6 November 2013

**Modification Request for the University of Sydney Abercrombie Precinct
Redevelopment: Application Number: MP07_0158 MOD 3**

Ground Floor Plan
1:200@A1
11.10.13
4001_DA02-D

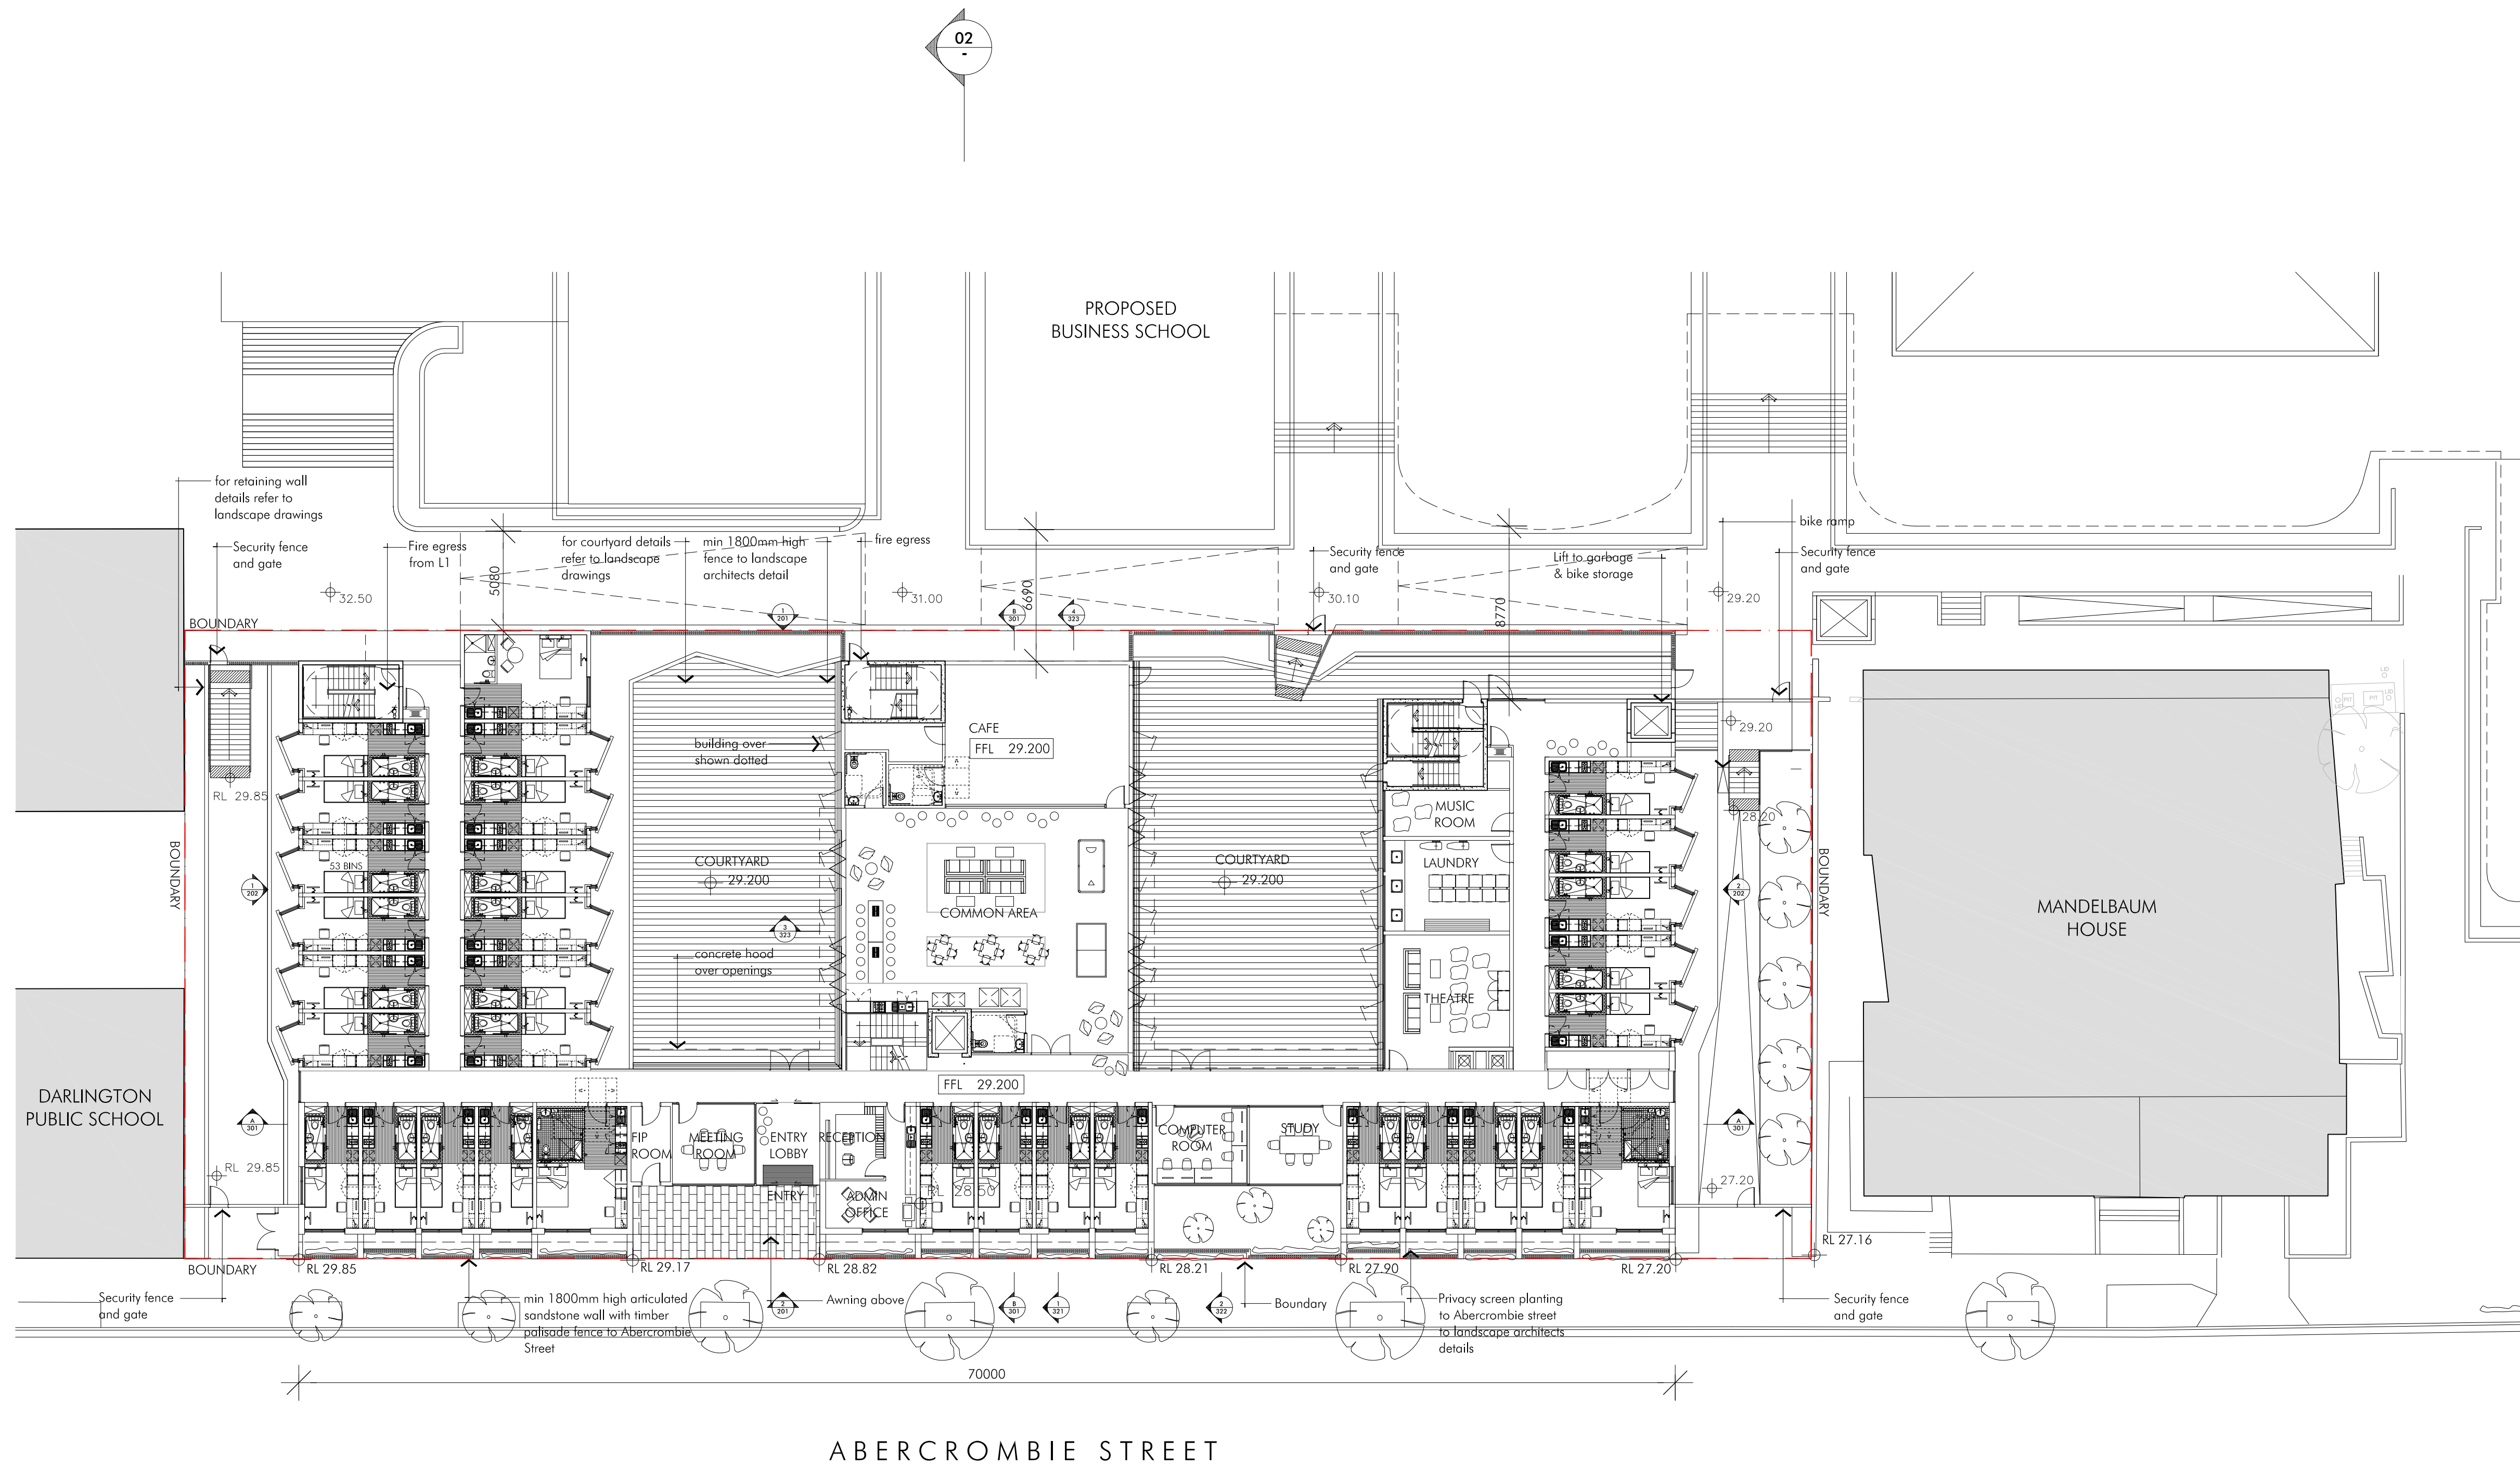
- The front of the Student Accommodation building should be built 2 metres back from the Abercrombie Street boundary. It should be set back from this boundary so that it is in line with Mandelbaum House as it was originally planned and presented to the community. The footprint of the buildings currently on the site, The Shepherd Centre and Boundary Lane Children's Centre, were built approximately 2 metres back from the Abercrombie Street boundary and align with Mandelbaum house. Therefore, the front footprint of the proposed Student Accommodation building should be the same as those buildings occupying the site at present and not be built up to the Abercrombie street boundary.

- The facade of the proposed Student Accommodation building does not reflect the heritage appearance of the Victorian terraces on Abercrombie Street as Mandelbaum House does. Therefore, it should be set back to allow for extensive vegetation and trees to be planted in front of the building on Abercrombie Street to help preserve the heritage streetscape and improve both the aesthetics and the environment of the street.
